Our ref: DOC21/662085-5

Your ref: SSD-8889679

Liddell Battery and Bayswater Ancillary Works Project (SSD-8889679) – Request for Advice

BCD's detailed comments

Legend

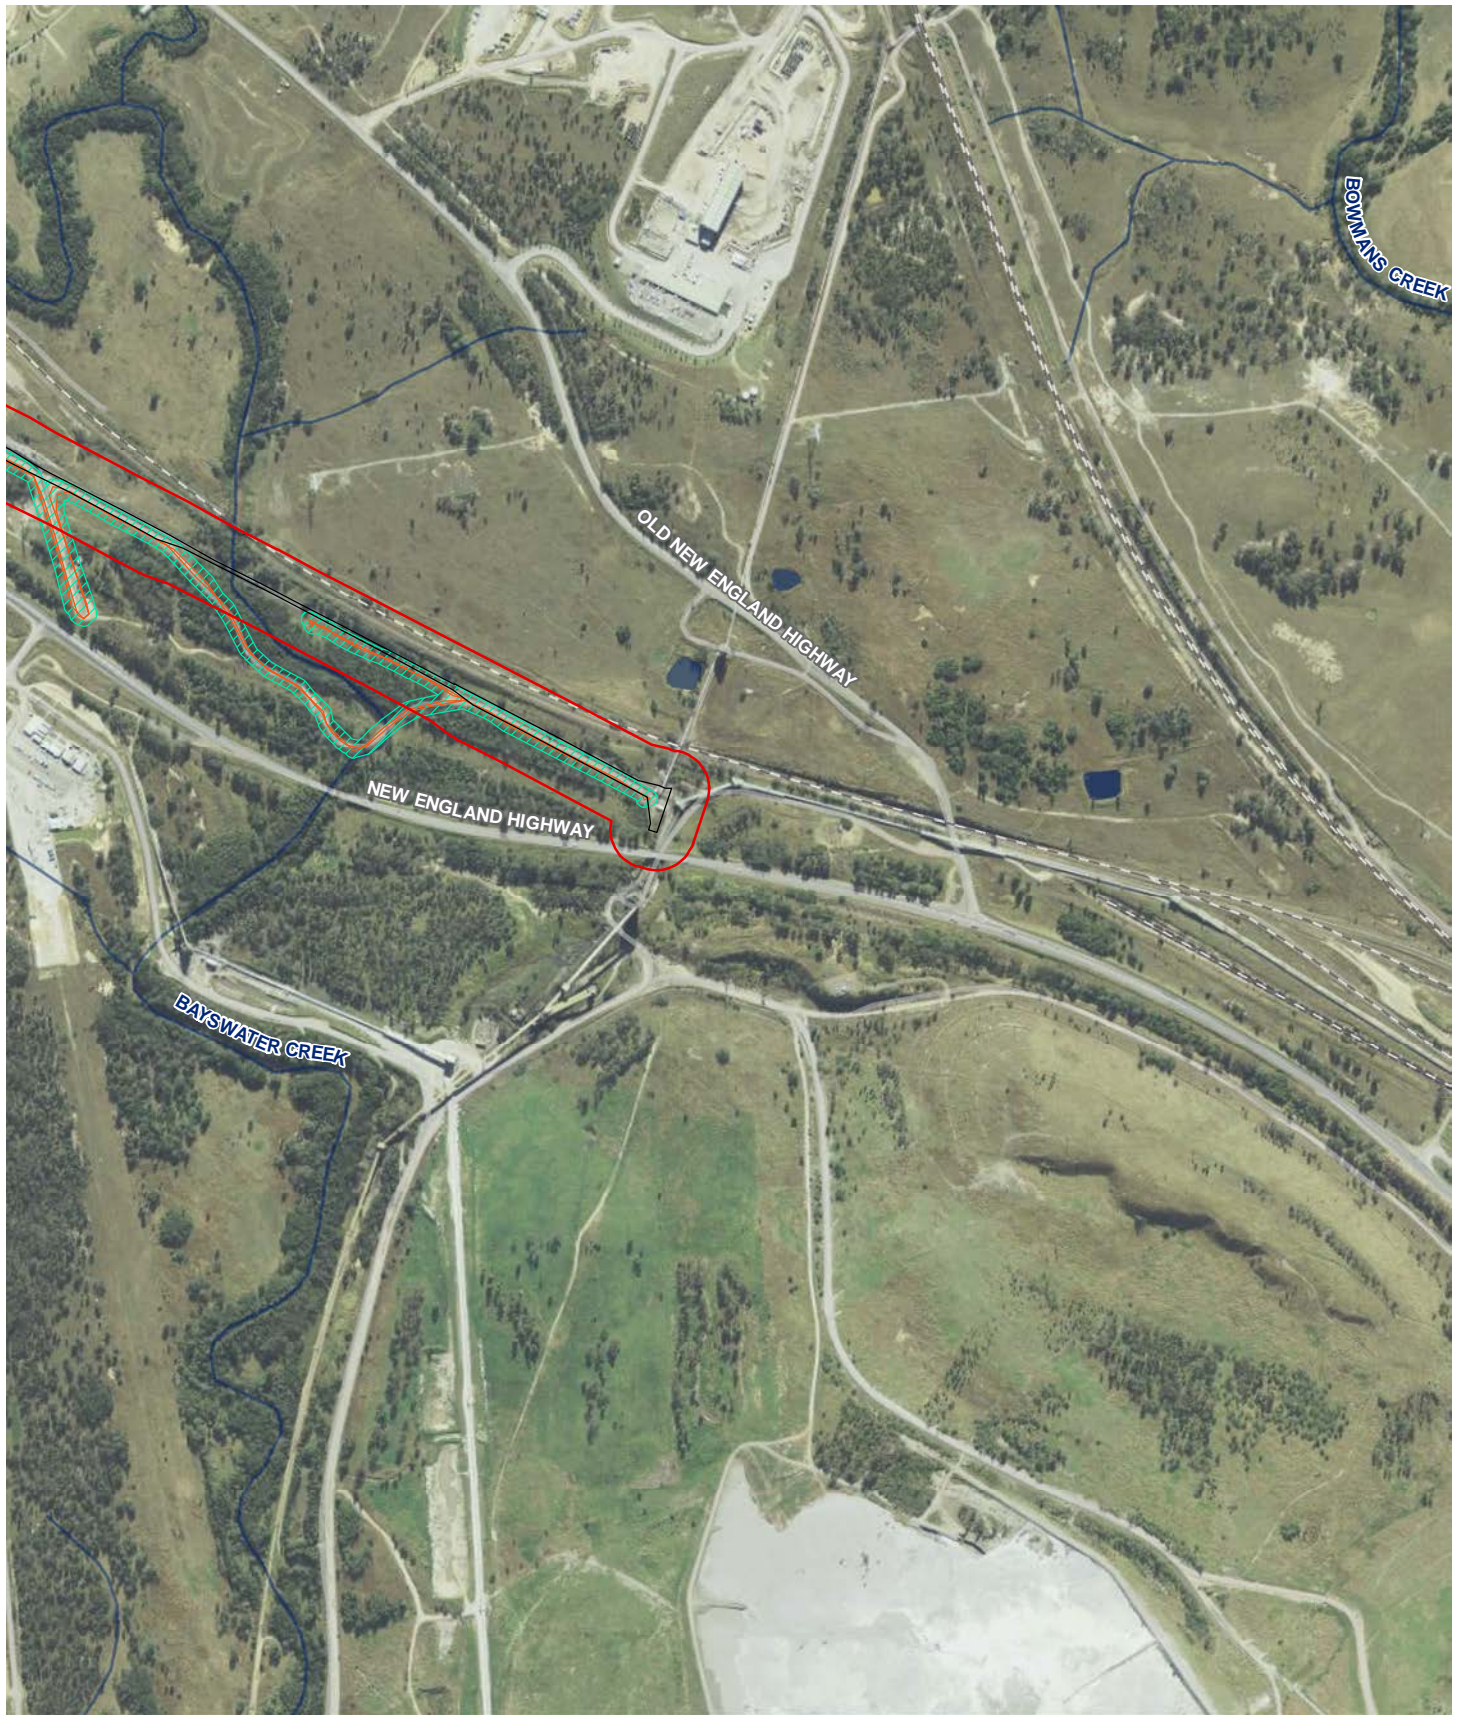
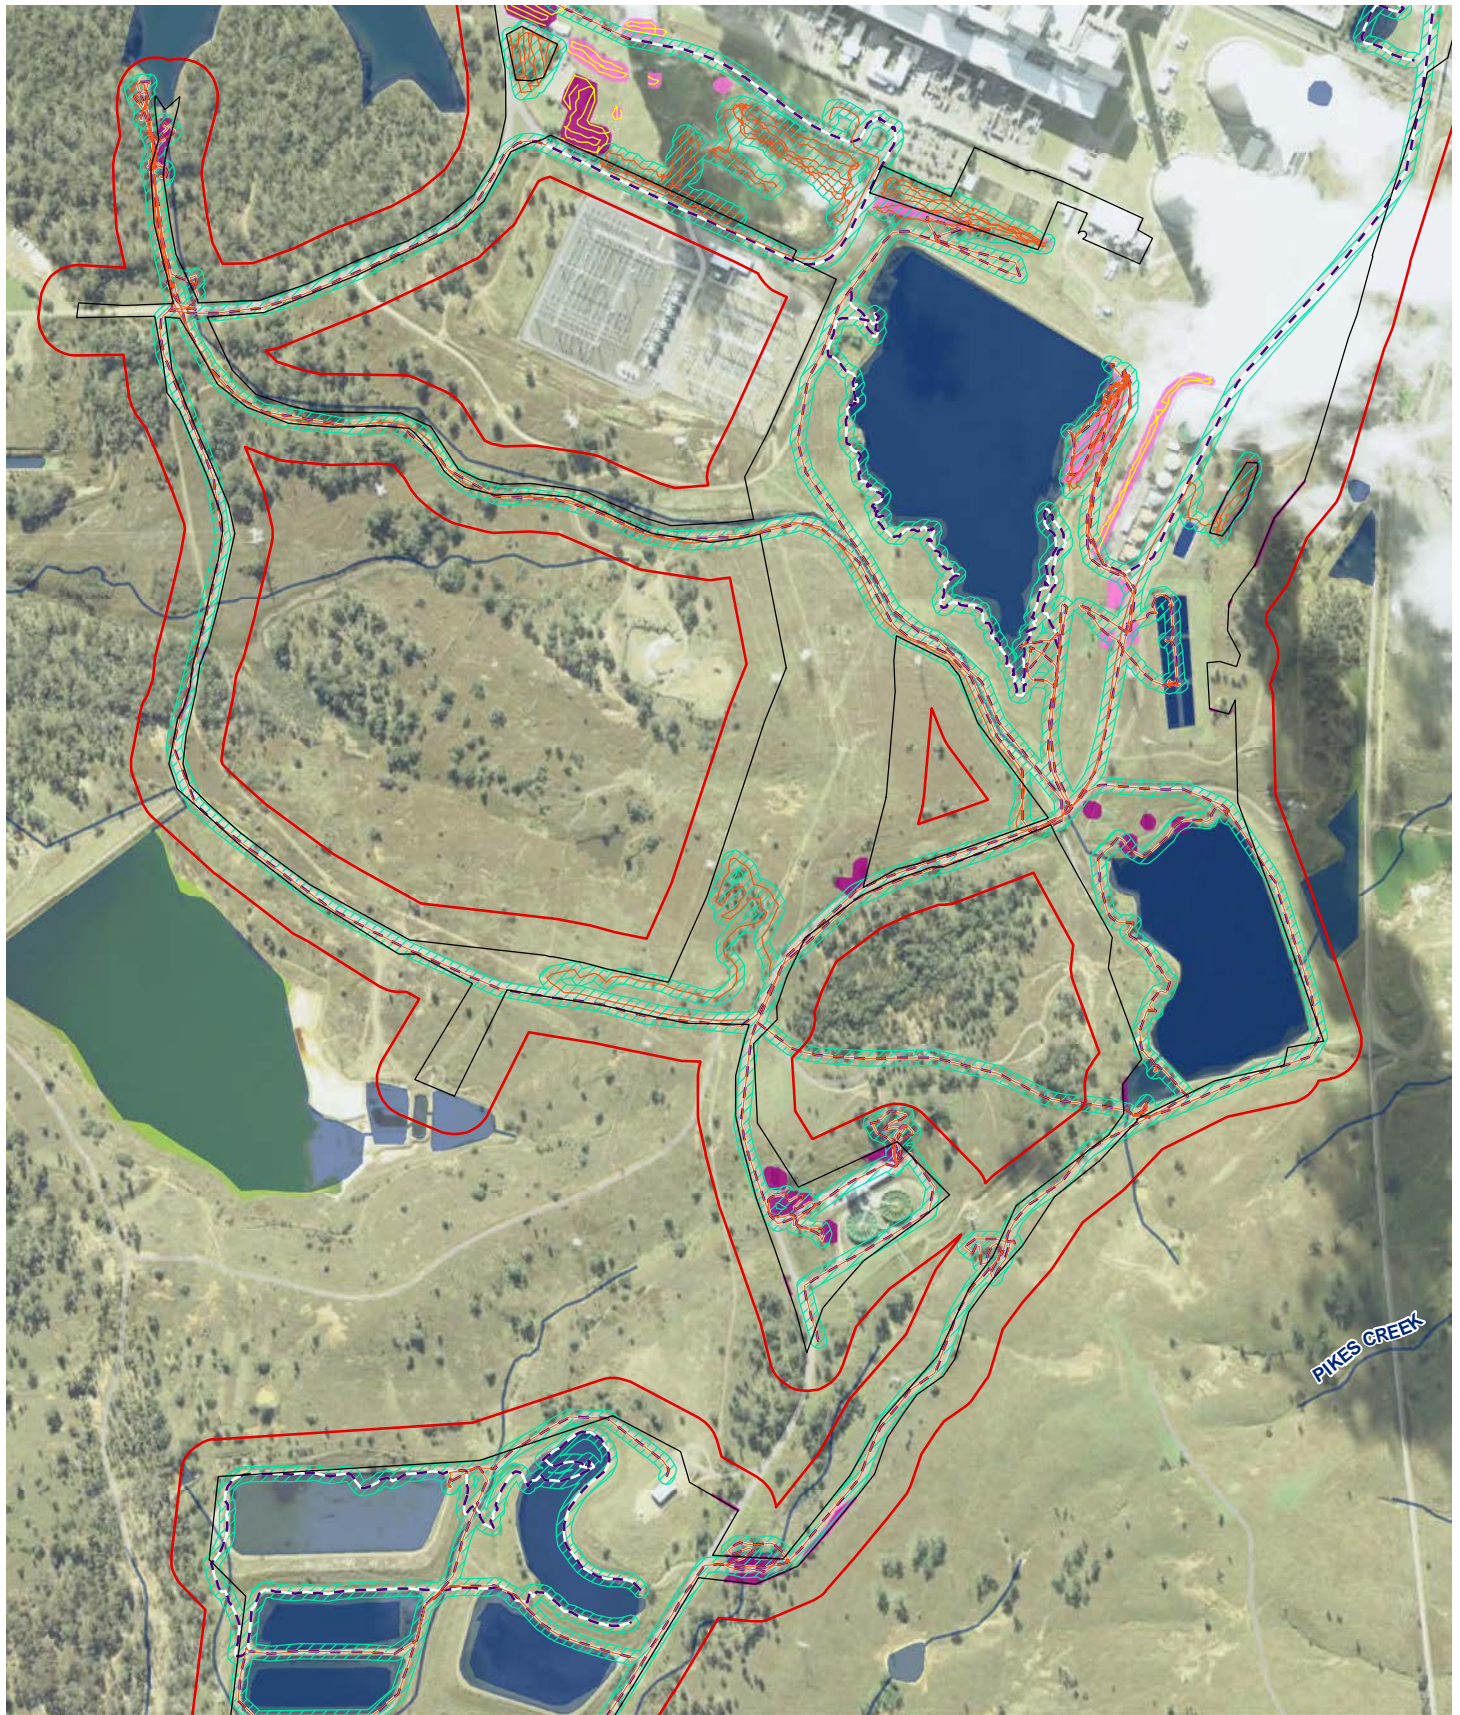
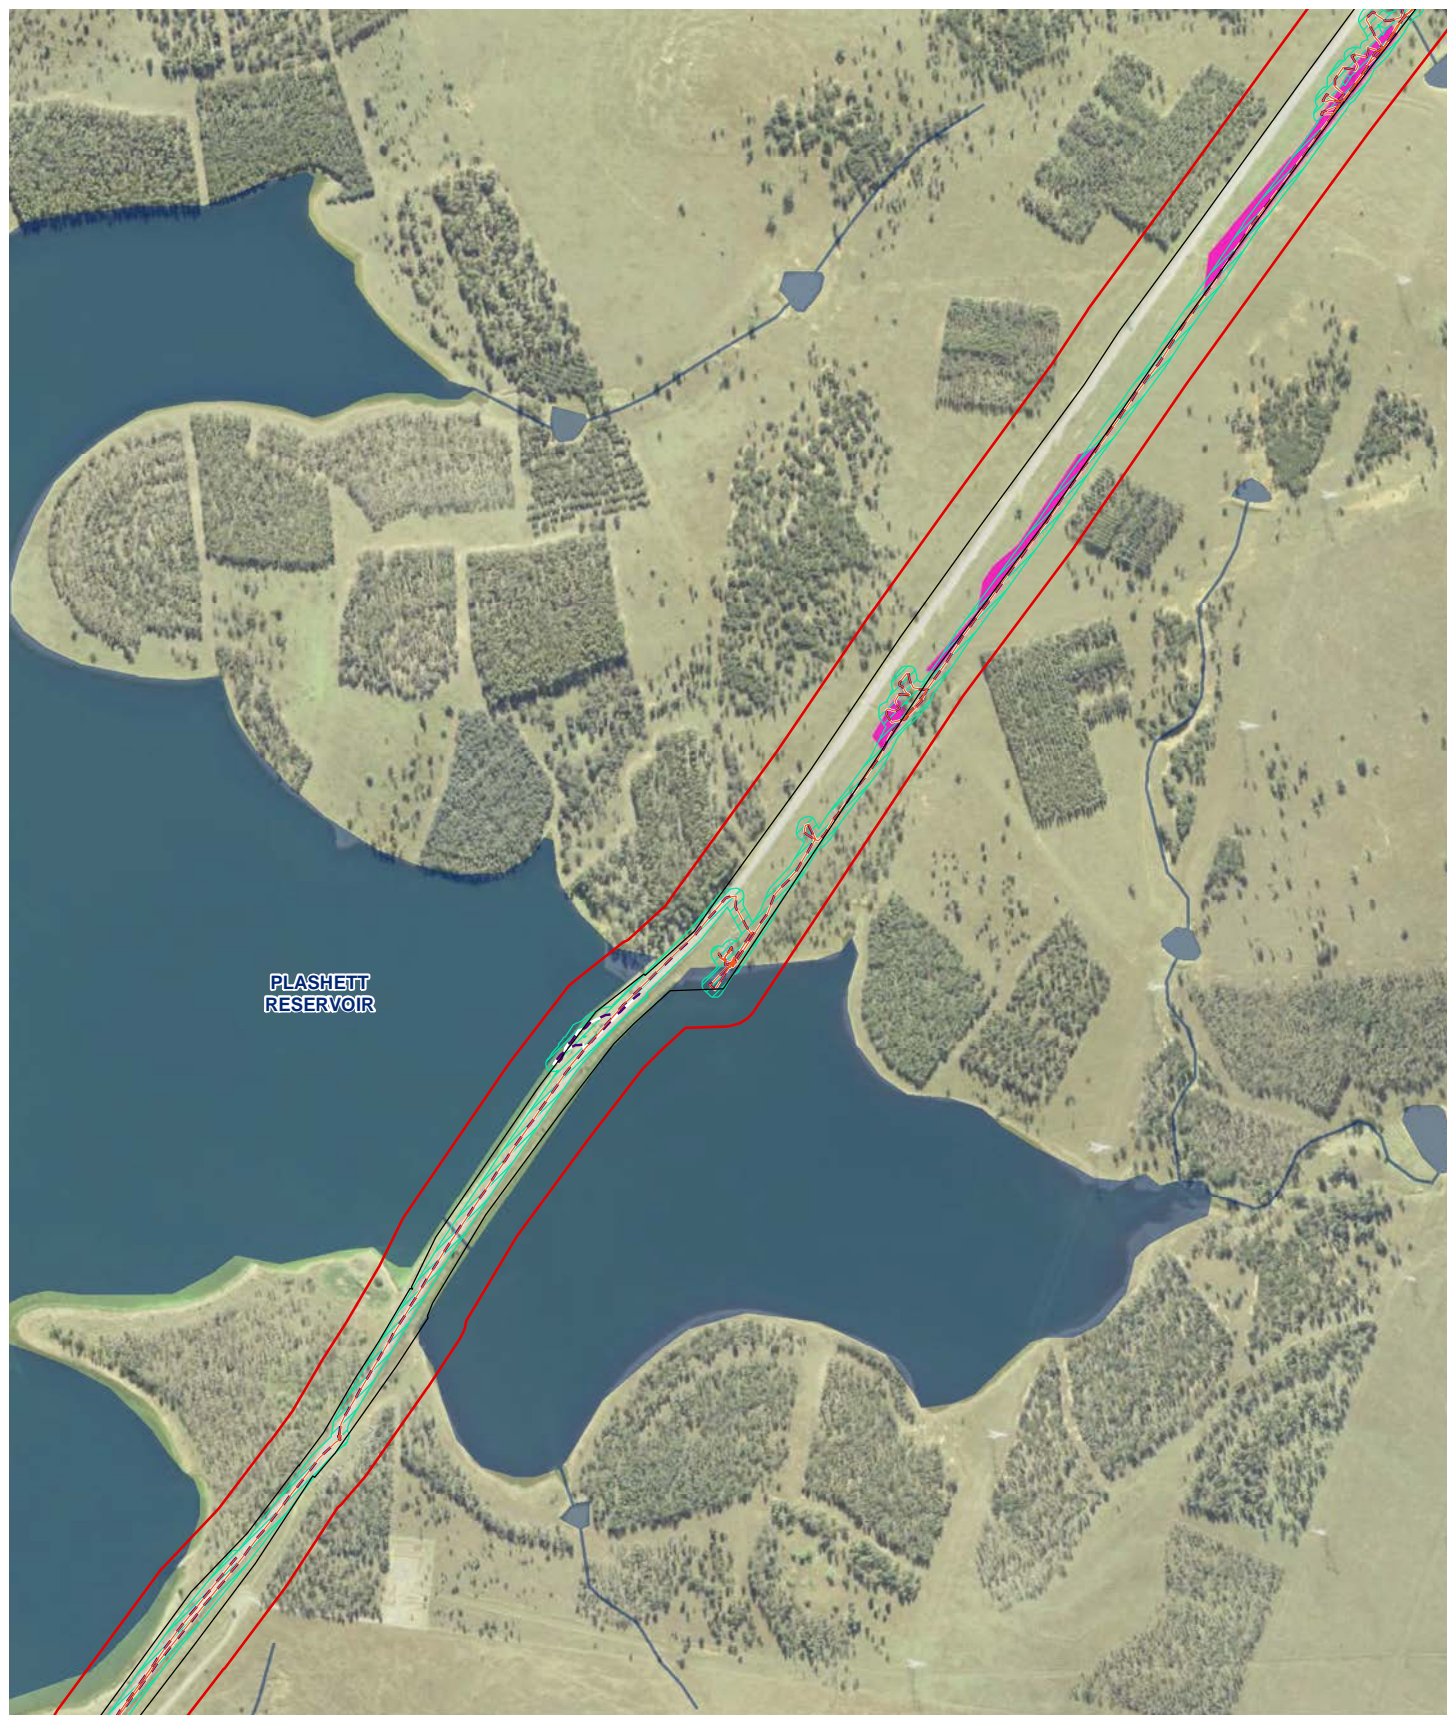
The targeted flora survey tracks shown in Figure 6-1 (pp. 66-80) and provided as shapefiles do not show that targeted flora surveys were conducted in all vegetation zones for PCT 1691 within the development footprint. This is apparent on pages 68-70, 75-76, 78 and 80.

This PCT is associated with threatened orchids *Pterostylis chaetophora* and Tarengo Leek Orchid (*Prasophyllum petium*) as well as Tall Knotweed (*Persicaria elatior*). Targeted flora searches should be conducted for these species in all vegetation zones for PCT 1691 in accordance with the requirements detailed in Section 4.2 of the *Surveying threatened plants and their habitats - NSW survey guide for the Biodiversity Assessment Method*.

BCD recommends that effort for targeted flora searches is demonstrated in all vegetation zones for Plant Community Type 1691 within the development footprint.
